18 December 2014

**SSD5093 – North Ryde Station Precinct “M2 Site”  
Response to Transport for NSW Submission**

We write on behalf of Urban Growth NSW to provide a response to the Transport for NSW (TfNSW) submission on the abovementioned Development Application for State Significant Development dated 19 November 2015. The following matters were raised:

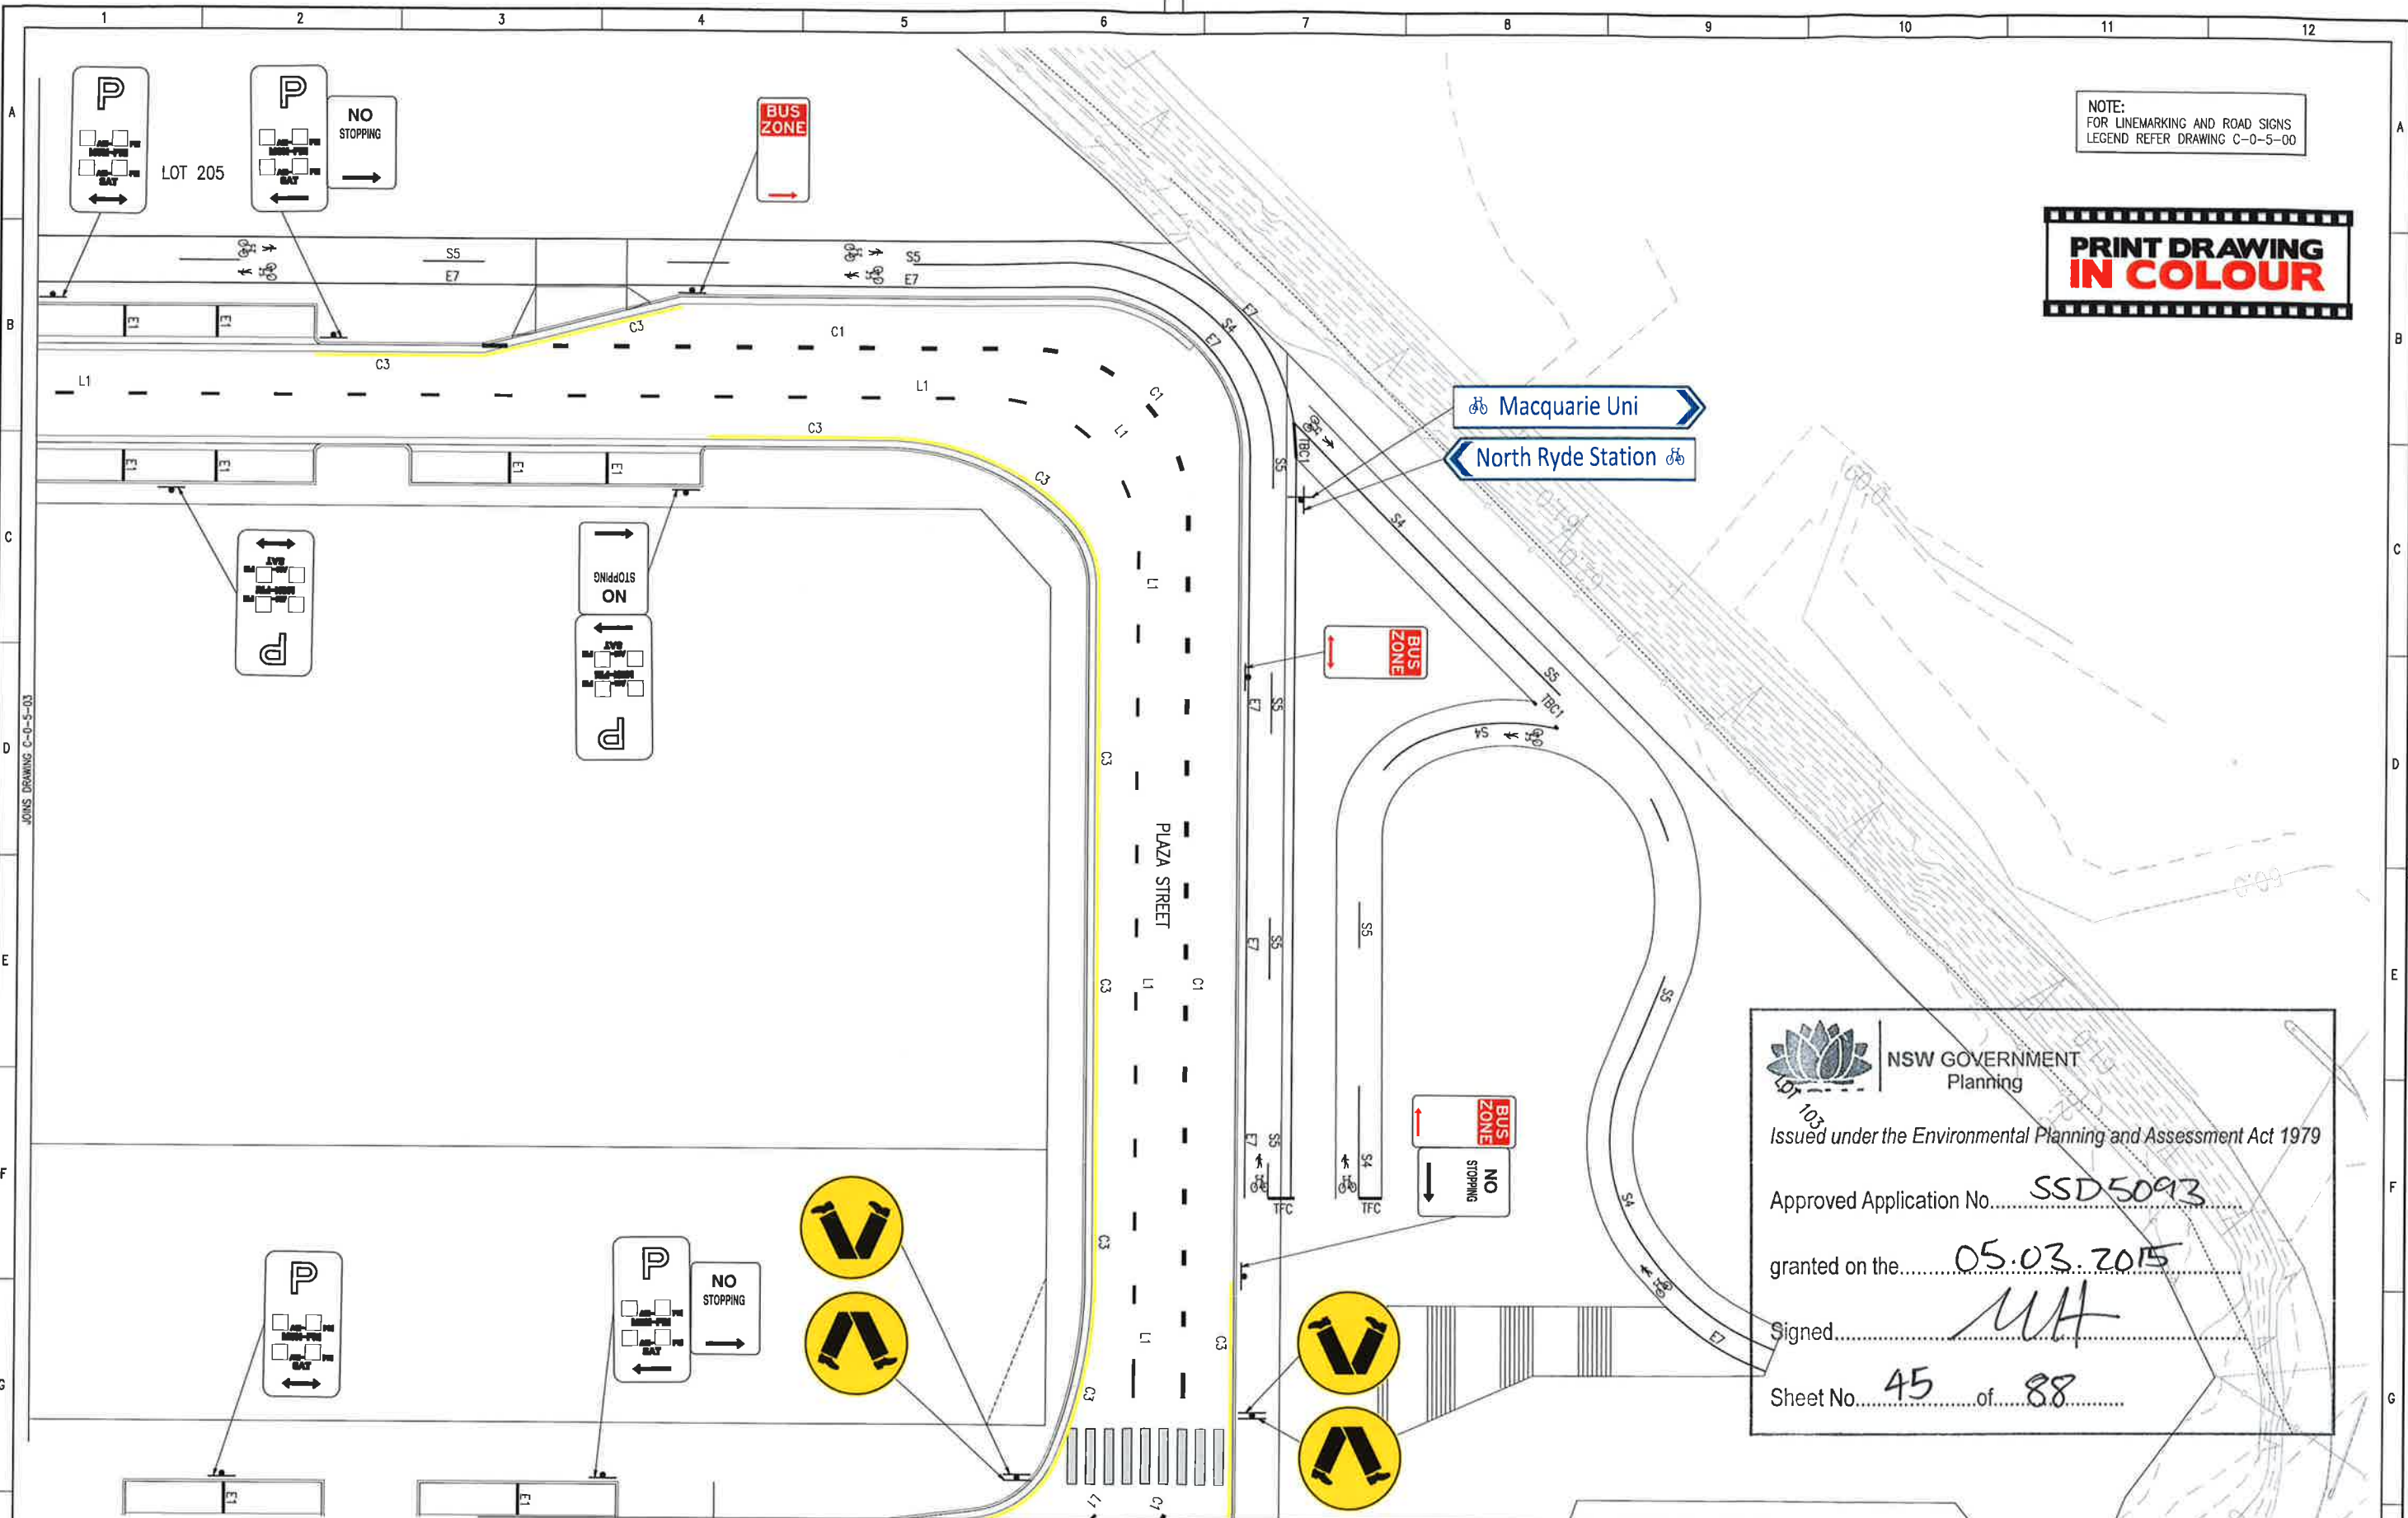
TfNSW requests written confirmation and an updated diagram that confirms that the three bus bays in the retail precinct are capable of accommodating an articulated vehicle. Signs and Line Marking Drawing C-0-5-0-4 prepared by Robert Bird Group submitted with the Response to Submissions shows the bus zone sign and line marking proposed on Park Street. Refer to drawing extract at Figure 1.

It is confirmed that the three bus bays provided in the retail precinct on Park Street and Plaza Street are designed to accommodate articulated buses and appropriate signs and line marking were provided on the civil drawings that accompanied the Proponent's Response to Submissions report.
